NORTH FALLS OFFSHORE WIND FARM DEVELOPMENT CONSENT ORDER

PINS REFERENCE EN010119

**DEADLINE 7: PORT OF LONDON
AUTHORITY'S RESPONSE TO EXAMINING
AUTHORITY'S THIRD WRITTEN QUESTIONS**

Deep Water Route Cable Installation Areas (Future Dredging Depths) Plan

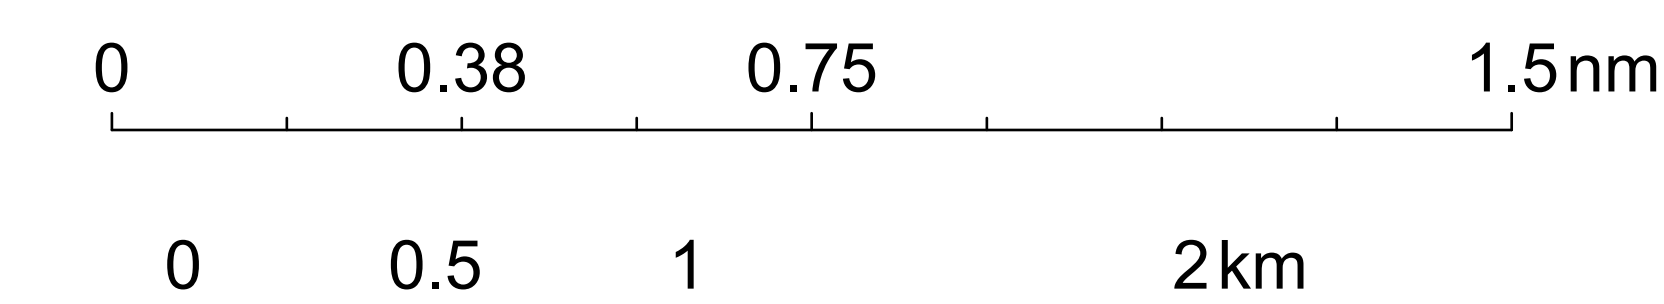
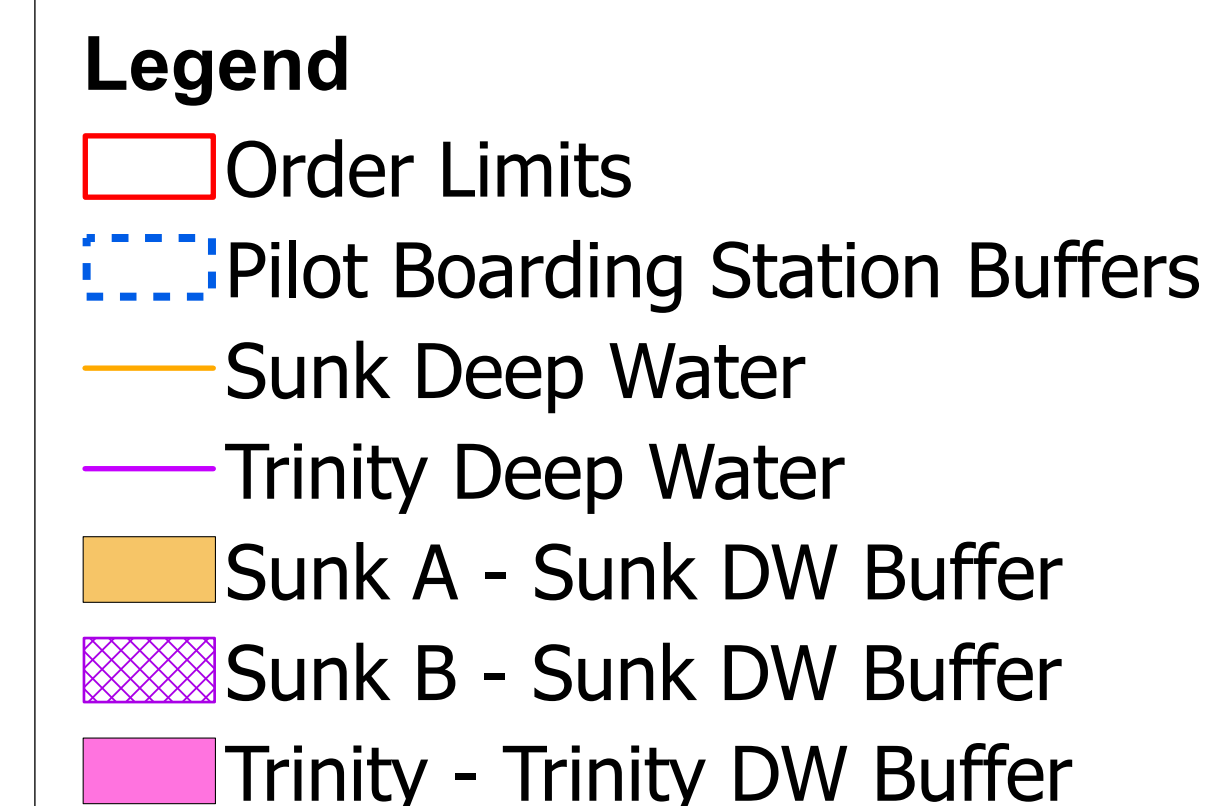
| ExQ3 | Question to: | Question: | PLA Response |
|---|--------------------------------|---|--|
| Q9.0.1 | Port of London Authority (PLA) | <p>Article 2 (Interpretation) Definition of ‘maintenance’</p> <p>The dDCO [REP5-008] requirement 2(3) provides that the Deep Water Route Cable Installation Area (Future Dredging Depths) Plan, must be designed, installed, operated and maintained at a specified level. Please can the PLA confirm that this provision overcomes its concerns in relation to the definition of ‘maintenance’ in Article 2. If not, please explain any outstanding concerns in that respect.</p> | <p>The PLA’s concern was that the definition of maintain in Article 2 Interpretation allowed for the cable to be adjusted and altered and that meant that the cable could be installed at one level and then maintained at a different level.</p> <p>With the wording proposed in the dDCO [REP5-008] that the Deep Water Route must be maintained at a level which would not preclude or impede dredging to a specific level, the PLA is content that even though the depth of the cable might alter as a result of maintenance, the Deep Water Route dredging depths would be safeguarded.</p> |

| Paragraph in Appendix 2 | PLA Proposed Change | The PLA's Reasoning and Justification |
|--|--|---|
| Area of Interest | Update definition to reflect colouring and naming convention for the plan "Area of Interest" means the area <u>any part of those areas</u> shown shaded in yelloworange, pink, green and blue on the Deep Water Route Cable Installation Area (Future Dredging) <u>Depths) Plan</u> depths) plan encompassing the Deep Water Routes; | Update definition to reflect colouring and naming convention for the plan. The change also picks up that the Applicant has additionally committed to include the area around the sunk pilot diamond, shown coloured blue on the Deep Water Route Cable Installation Areas The Area of Interest is any part of the areas coloured and so the definition should refer to any part for clarity. There is more than one area. The PLA did wonder whether this should in fact be Areas of Interest but have left as drafted. The coloured areas also encompass the sunk pilot diamond and so we suggest deleting reference to "encompassing the Deep Water Routes" |

| Paragraph in Appendix 2 | PLA Proposed Change | The PLA's Reasoning and Justification |
|-------------------------|--|--|
| Paragraph 116 | <p><u>Cable Specification and Installation Plan</u></p> <p>The cable specification and installation plan referred to in paragraph 115 must be informed by a cable burial risk assessment,– and set out for Work No.2(e)3, <u>and</u> in so far as it applies to the Deep Water Routes <u>demonstrate compliance with requirement 2(3)</u>:</p> | The reference to Work No 2(c) should be Work No 3 and the cable burial risk assessment needs to demonstrate compliance with wording in requirement 2(3). This is consistent with the ExA's update to Schedule 9 Part 2 Condition 22(1) (h) (ii). |
| | <p>(a) that any part of Work No.2(c), any associated development or ancillary works located within the Area of Interest as shown shaded yellow on the Deep Water Route Cable Installation Area (Future Dredging depths) plan must be installed at a level which would not <u>preclude or</u> impede the dredging of those parts of the <u>Sunk and Trinity</u> Deep Water Routes:</p> <p>(i) shown shaded in <u>orange yellow and outlined in a bold black line</u> (and labelled Sunk <u>Area A – Sunk DW Buffer, (22m CD)</u>) to a level of 22 metres below Chart Datum;</p> <p>(ii) shown shaded in <u>pinkyellow and outlined in a blue dotted line</u> (and labelled Trinity <u>(22m CD) – Trinity DW Buffer,</u> to a level of 22 metres below Chart Datum; and</p> <p>(iii) shown shaded in <u>greenyellow and cross hatched in orange</u> (and labelled Sunk <u>Area B (19m CD) – Sunk B – Sunk DW Buffer,</u> to a level of 19 metres below Chart Datum.;</p> <p><u>(iv) shown shaded in blue and labelled Sunk Pilotage Area – Sunk Pilot Diamond Buffer, to a level of 22 metres below Chart Datum</u></p> | Updated to reflect the colouring on the Deep Water Route Cable Installation Area (Future Dredging depths) plan and the fact that the definition of Deep Water Routes includes the Sunk Pilotage Area |
